Subject: FW: Further Information Required on Your Ref: PP-08228993 Our Ref: BN/96/19/L

I still require scalable plans for the partial west elevation showing more of the existing house (to include the orangery) and a full south elevation (to include the orangery). The photos are fine but they are not scalable and will be added to the file for reference.

Barnham Court, Church Lane, Barnham, Bognor Regis, PO22 0BP

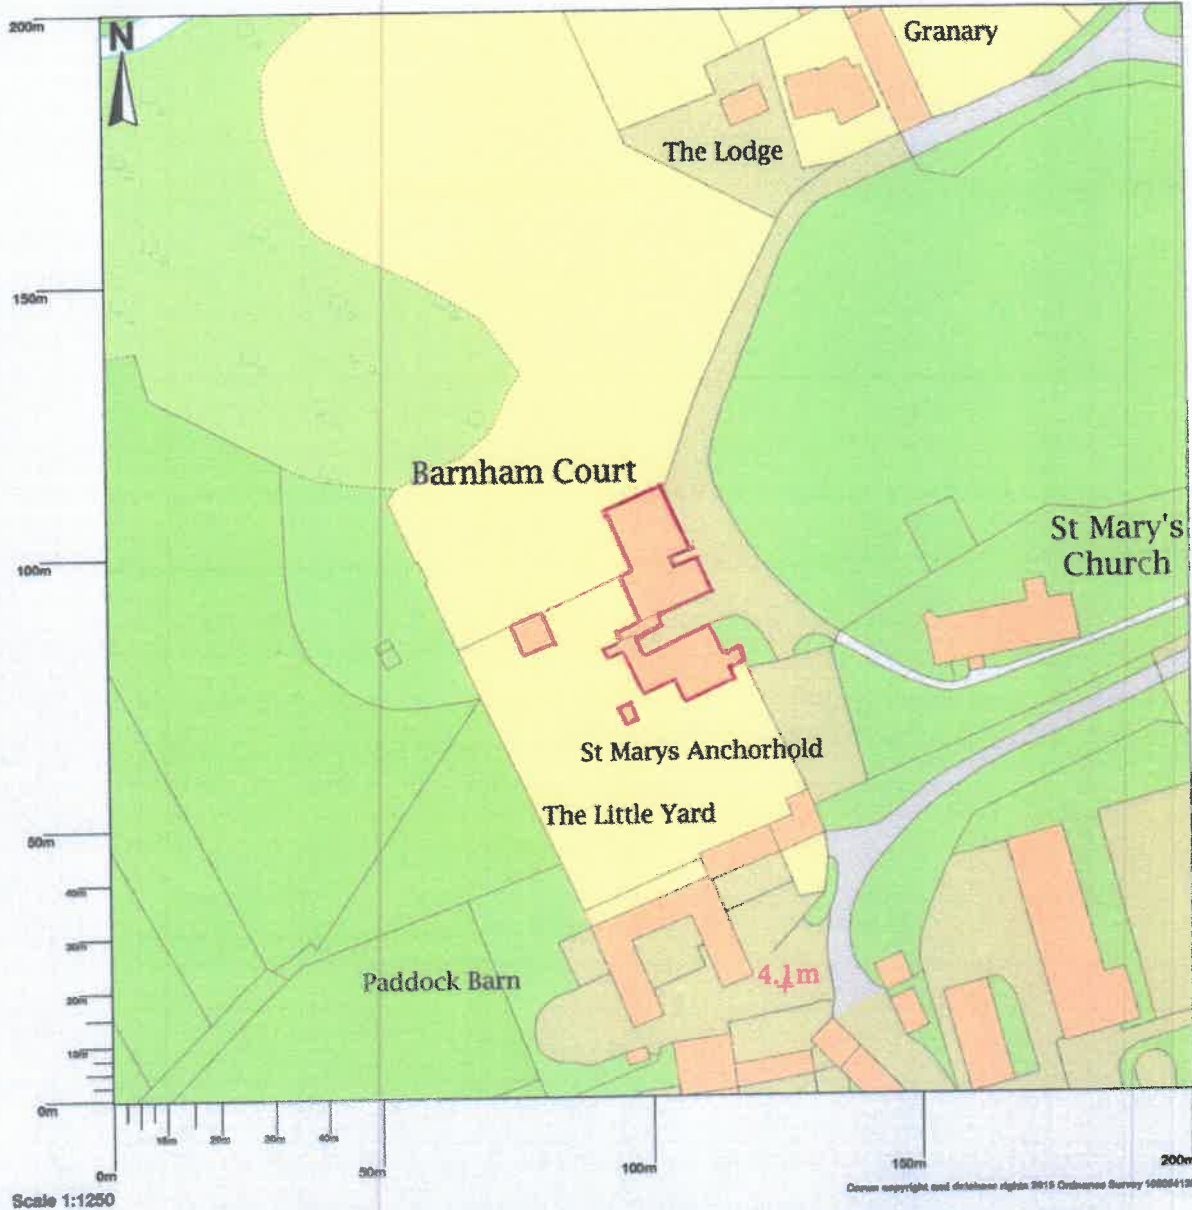
A Block plan is also required for this application. The block plan needs to be at a scale of 1:500 or 1:200 with a north point and clearly showing the proposals.
